Application no: H14/0777/00

Description: Extension to form first floor office space

Amendment: Amended design
Site location and elevational plans

**EXTENSION TO FORM FIRST FLOOR OFFICE SPACE
MILL GREEN ROAD PINCHBECK SPALDING**

| DRAWING  | Proposed Floor Plans & Elevations     | SCALE     | 1:100 1:50       |

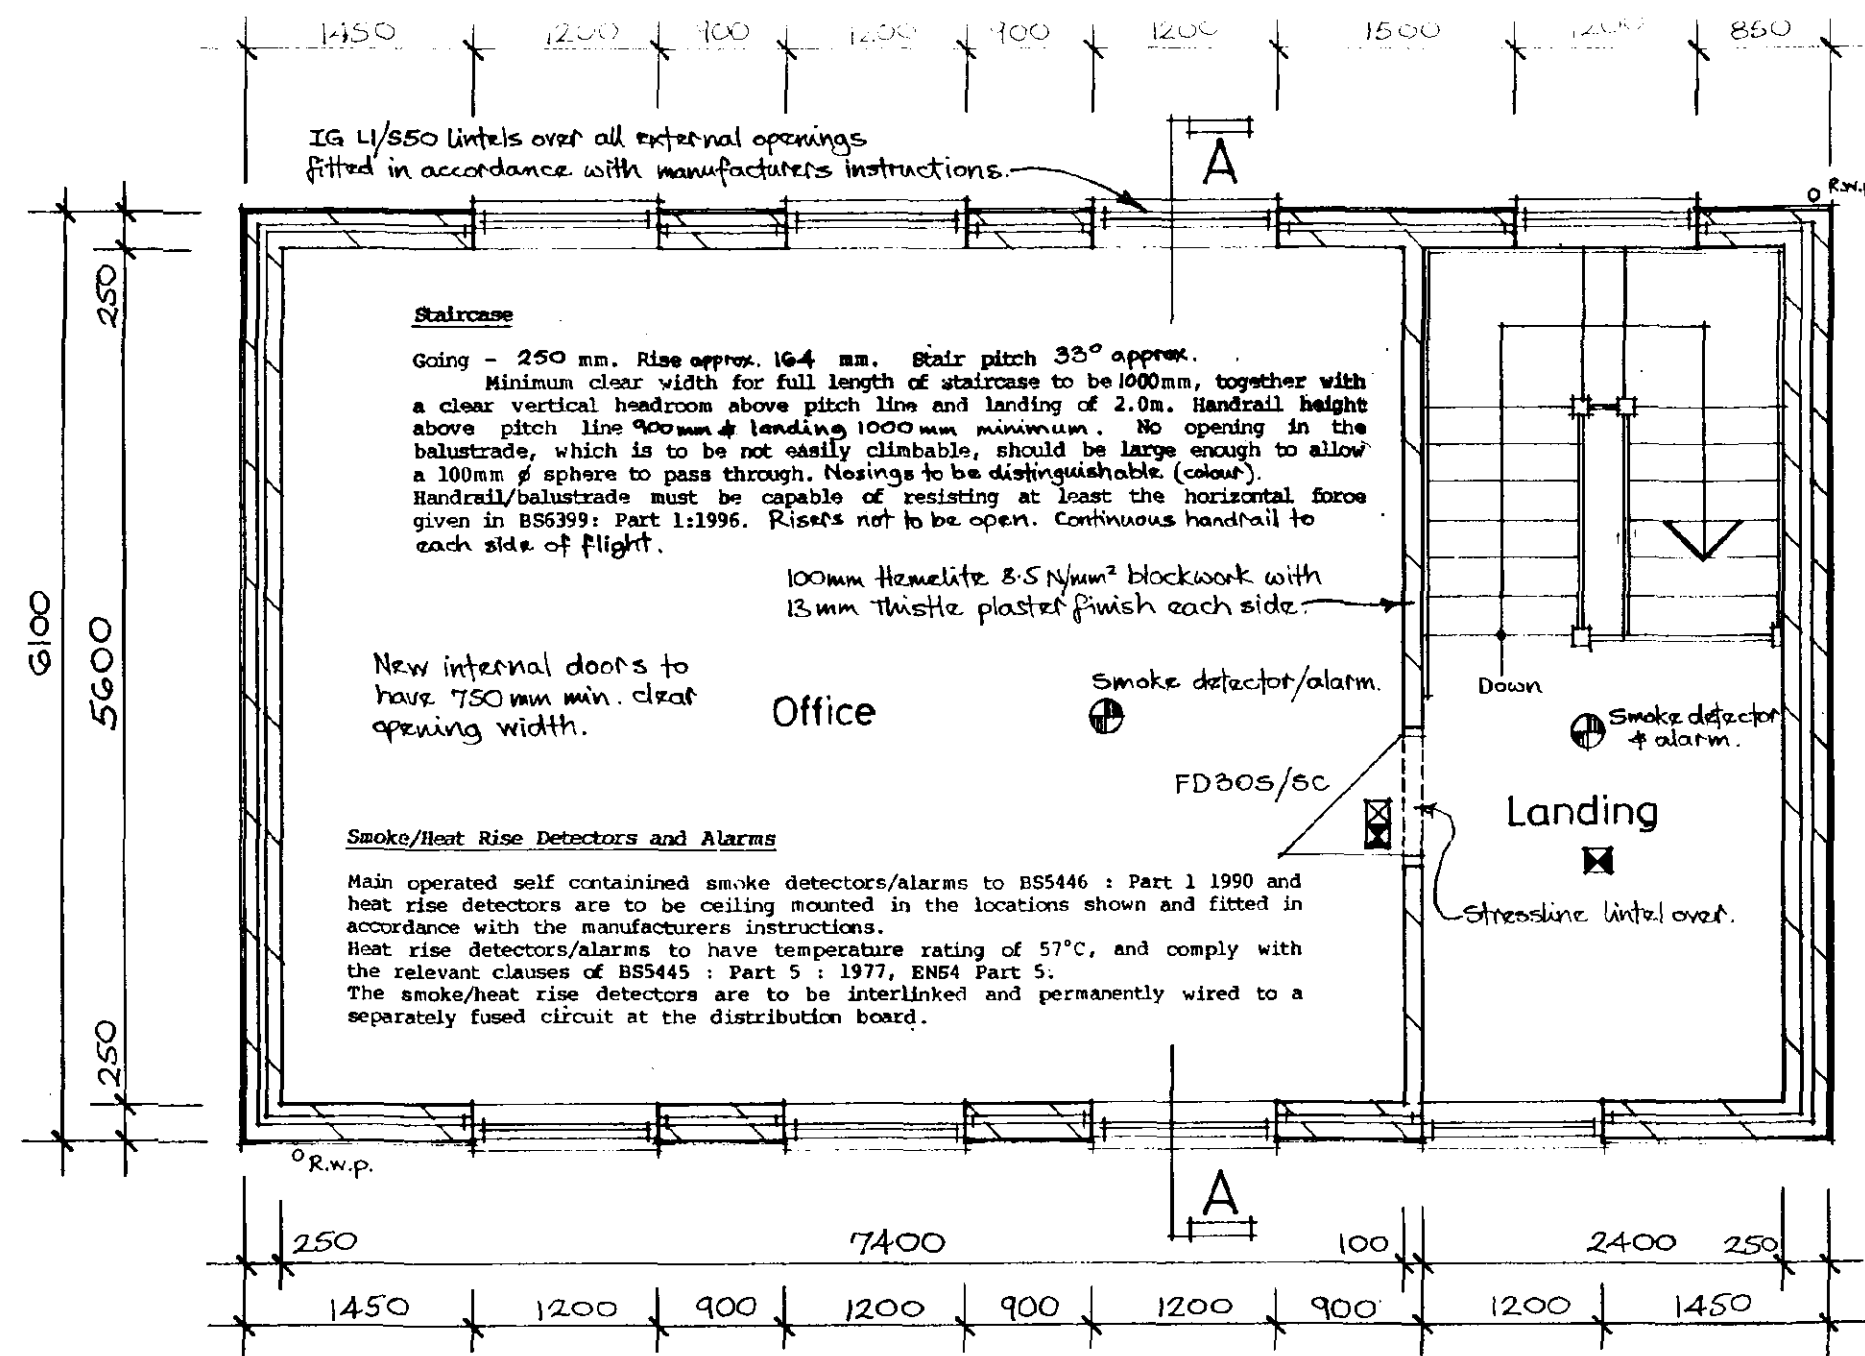
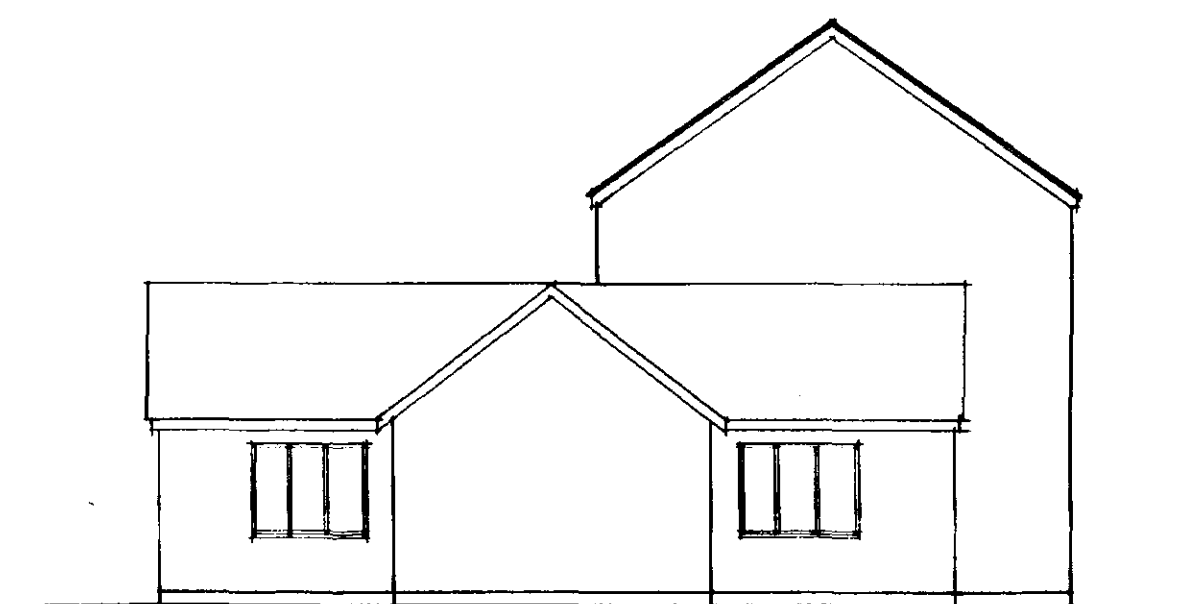
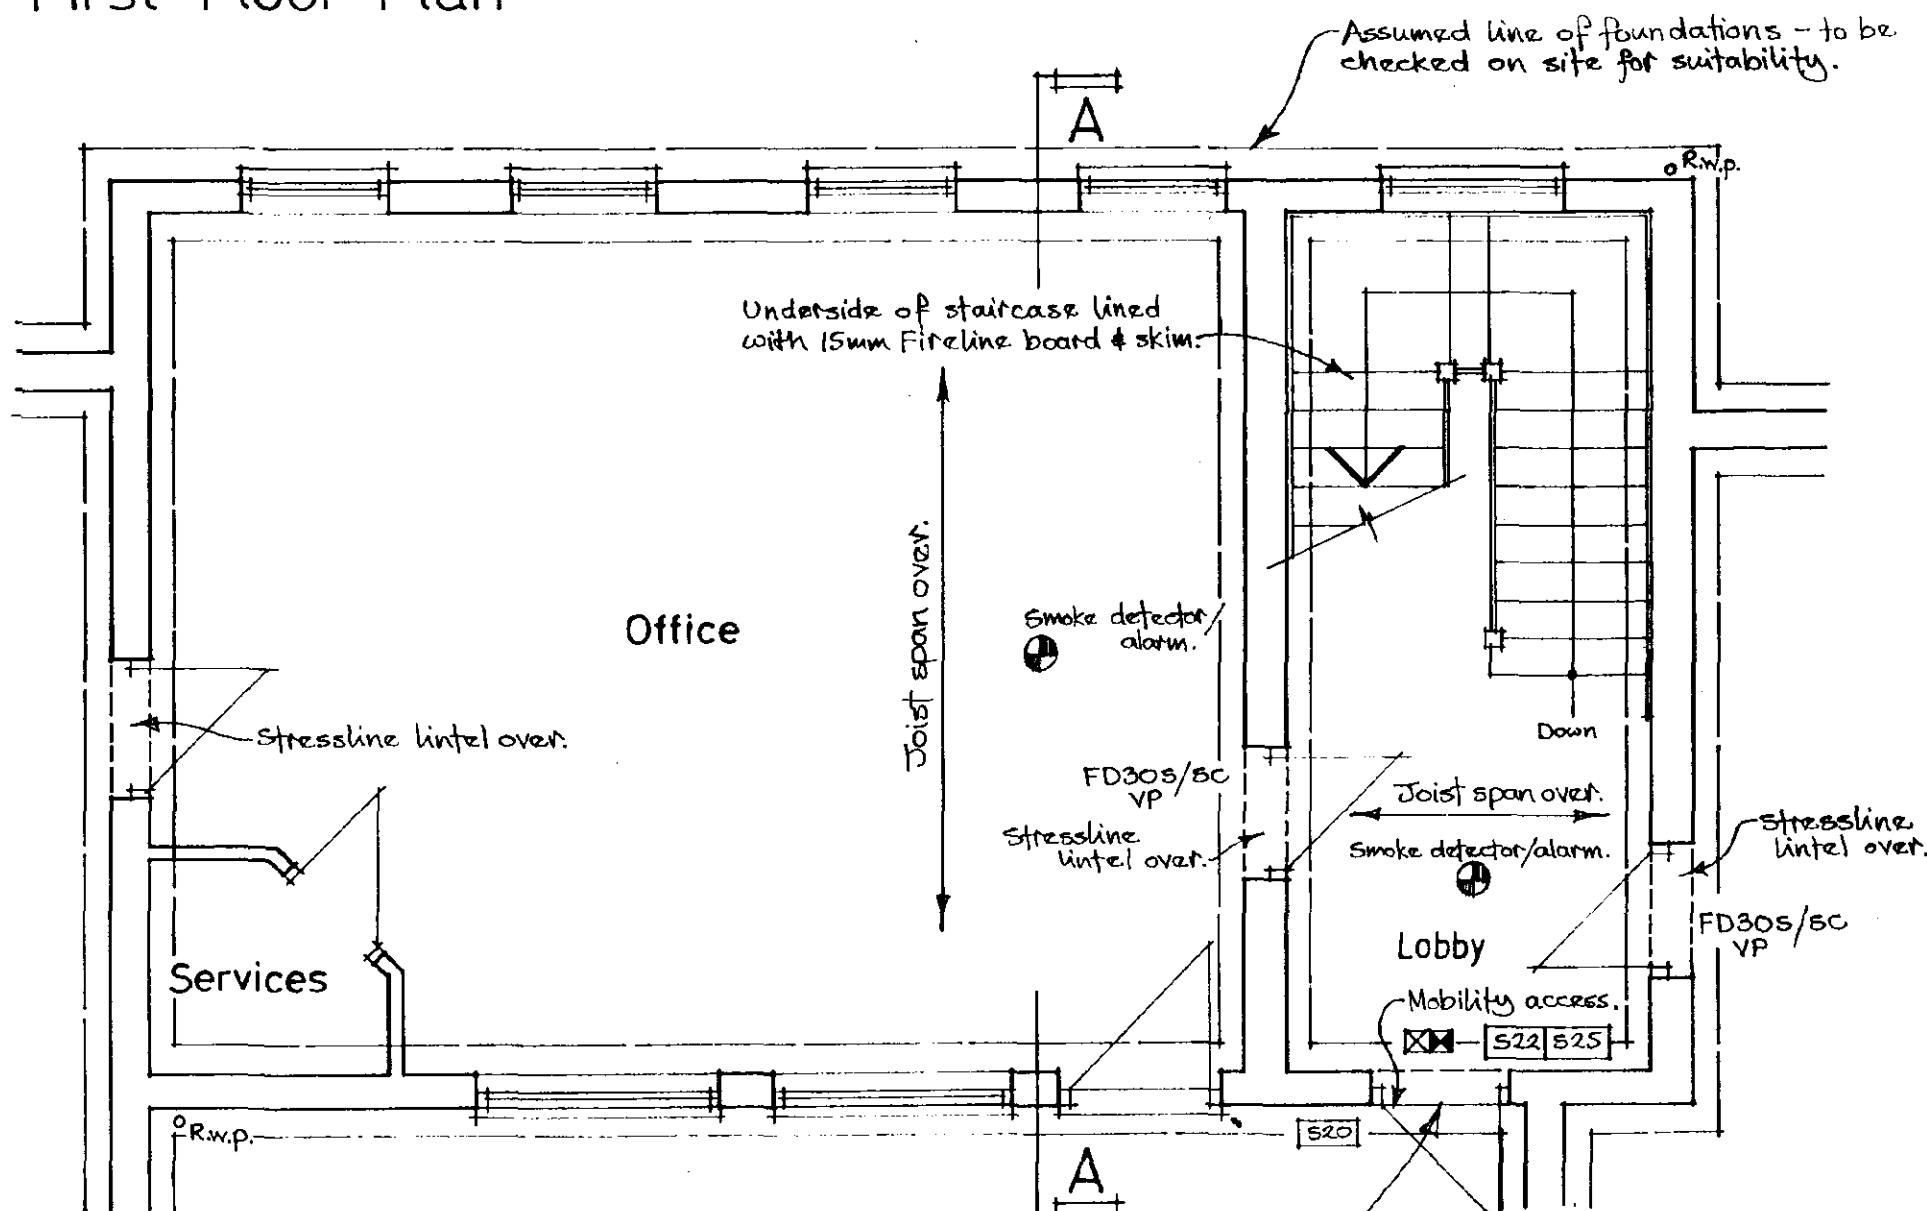
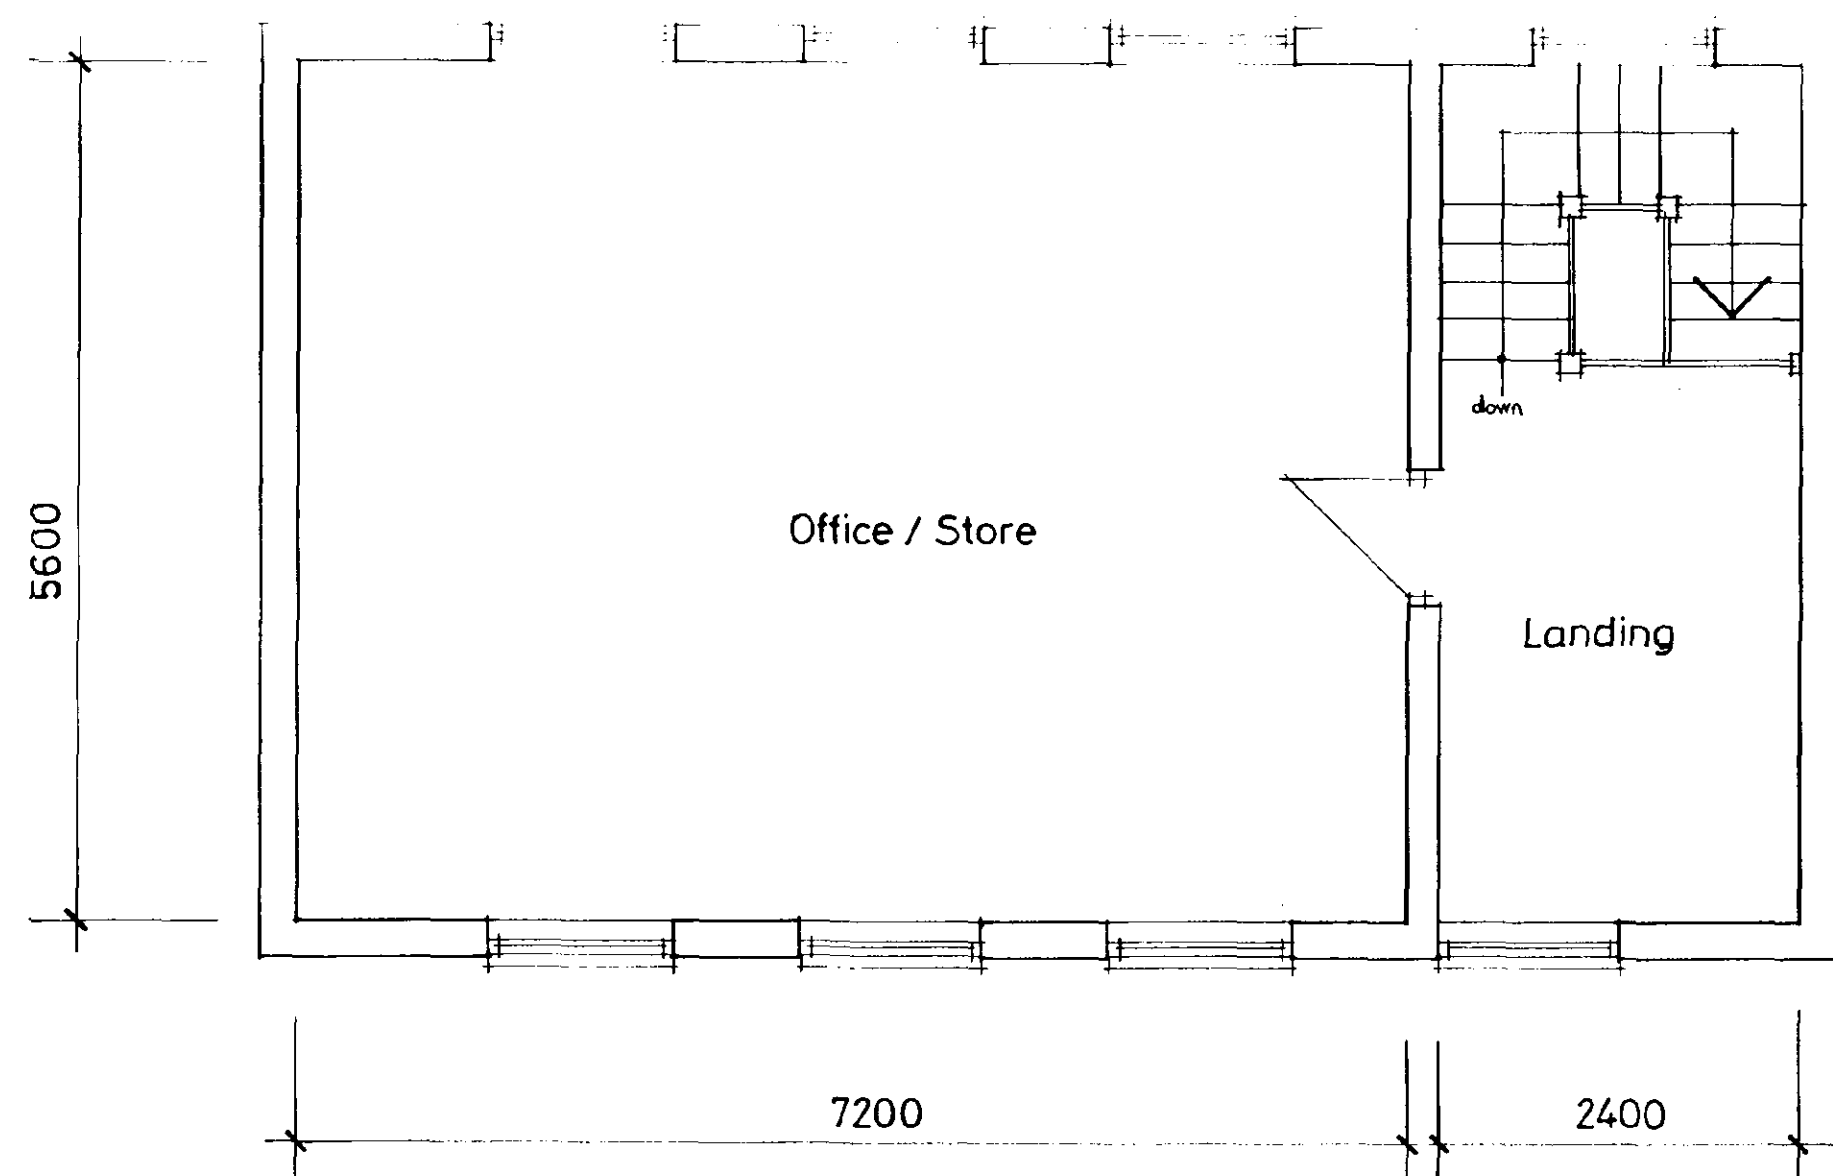
Dormas
removed

Please find enclosed herewith a drawing showing an amendment to the design approved on 4 August 2000 in respect of Application No. H14/0777/00. The original scheme was to insert a long dormer on each roof slope of the existing roof. This has now been changed so as to bring the eaves up to the top of the window heads on each side. The roof covering was to be in grey profiled steel, but the amendment would allow for the use of Redland Regent pantile profiled tiles to be used to give a traditional appearance.
